Re: Framing Issue
Location: Lot 334 Serenity (59 Firefly Ln. Fuquay-Varina, NC)
JDS Project No.: RDU2510488
Date of Inspection: 10/09/2025

Observations

S2.0

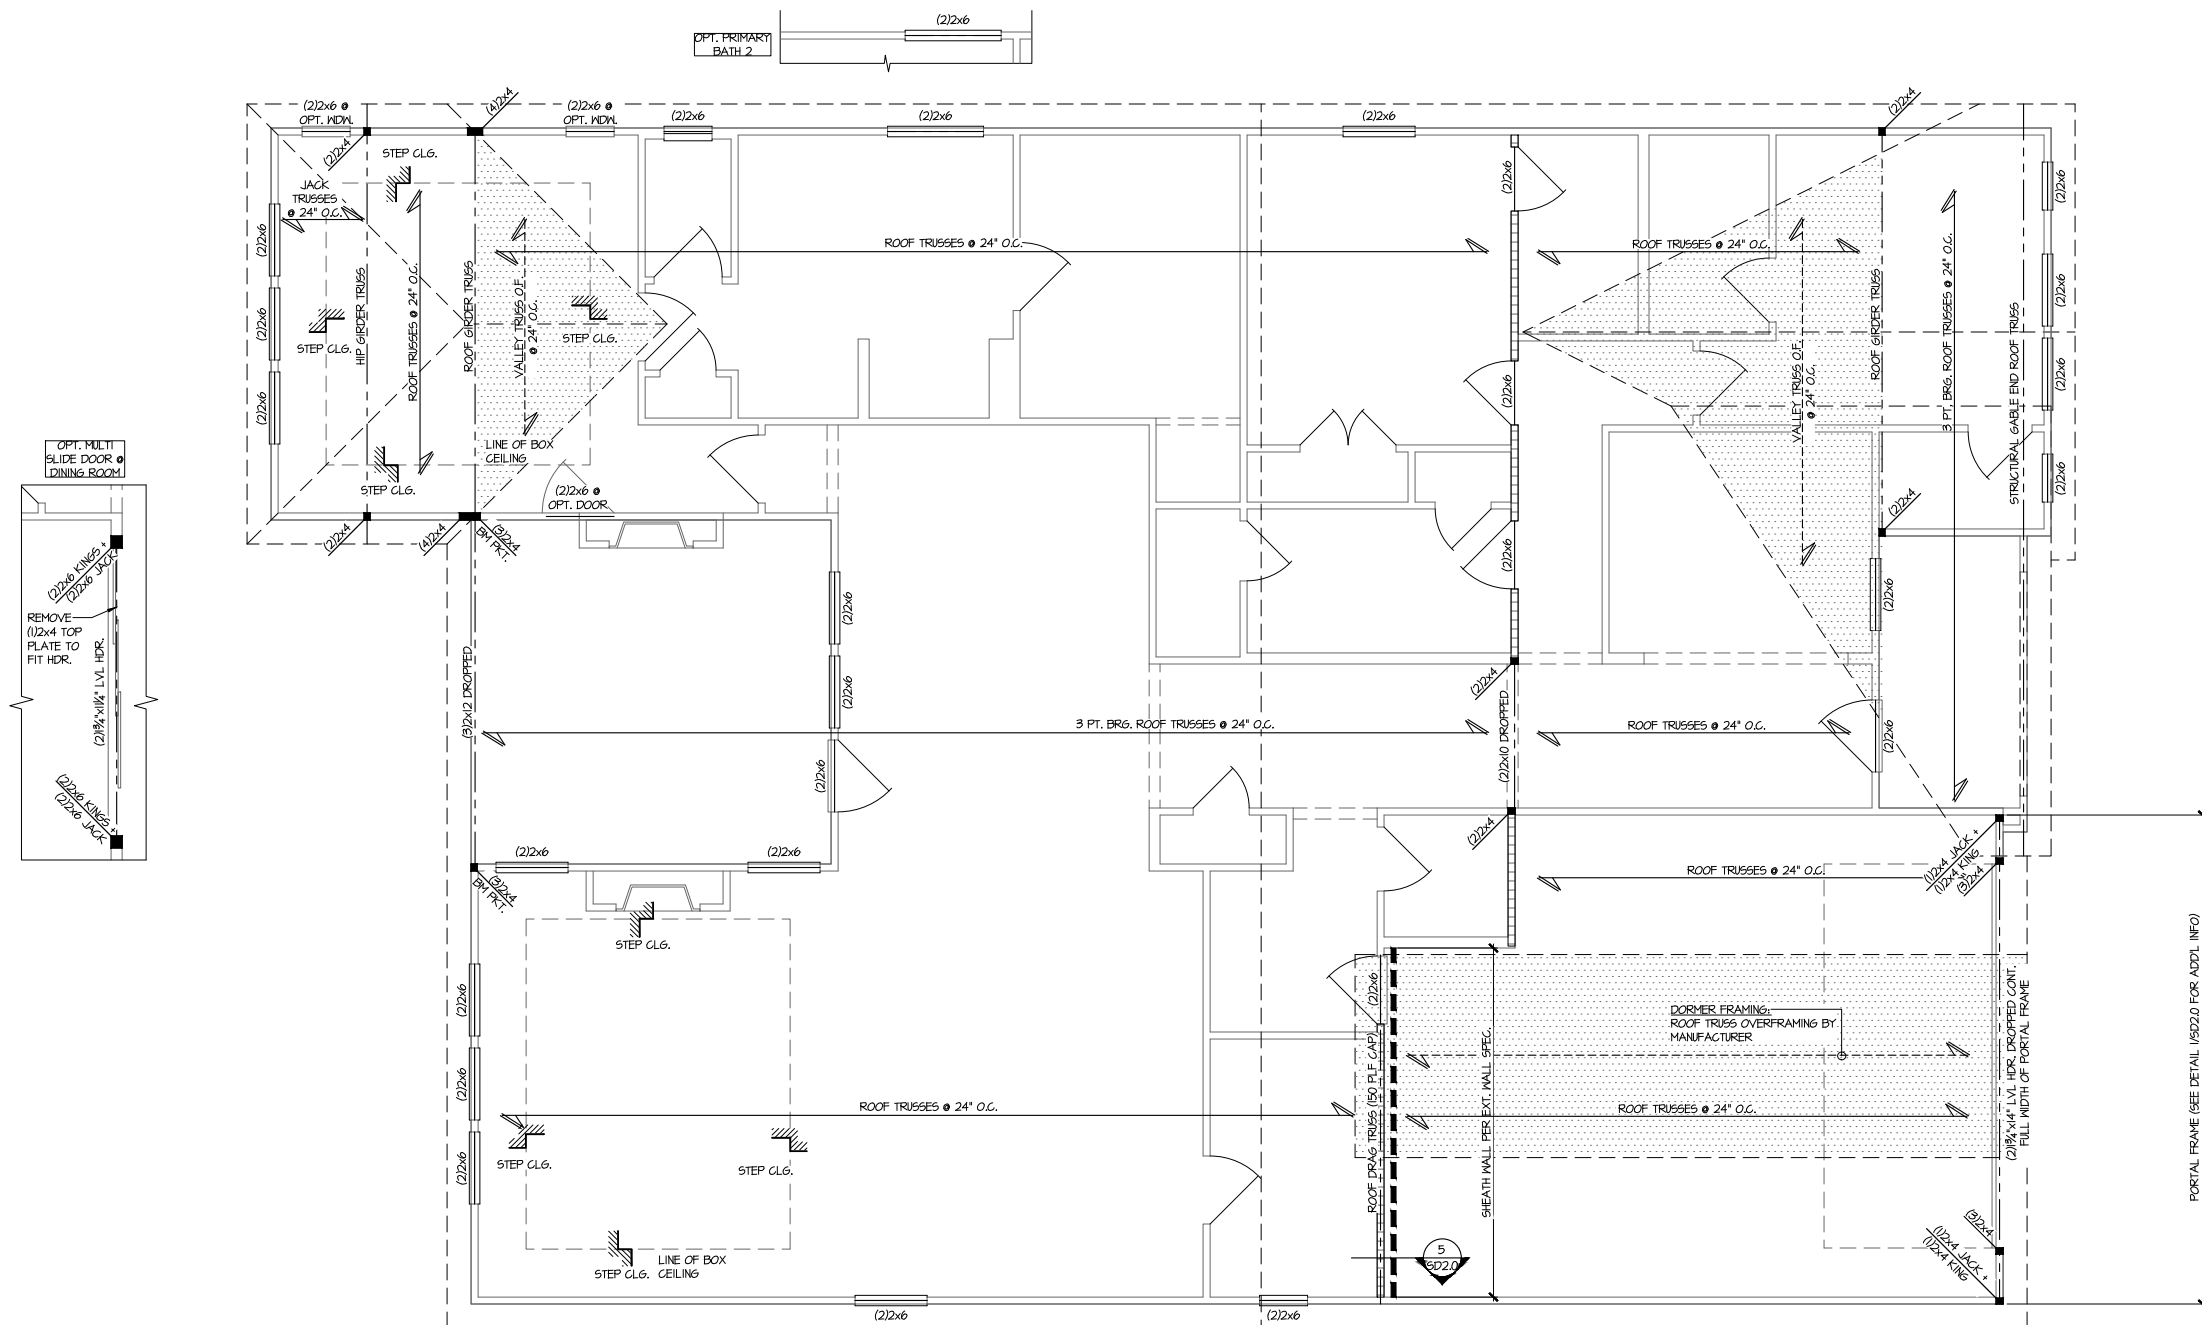
An evaluation has been requested above the owner's closet where the layout calls for a G01 girder truss to carry (6) C11 roof trusses to the rear and (6) floor joists to the front. A (2) 14" LVL beam has been installed with field framing for the 2nd floor finished area above, in lieu of the G01 girder truss.

Based on our onsite observations and review, the (2) 14" LVL beam with 2x4 field framing above is adequate to support and transfer the anticipated loading conditions. No repair is required.
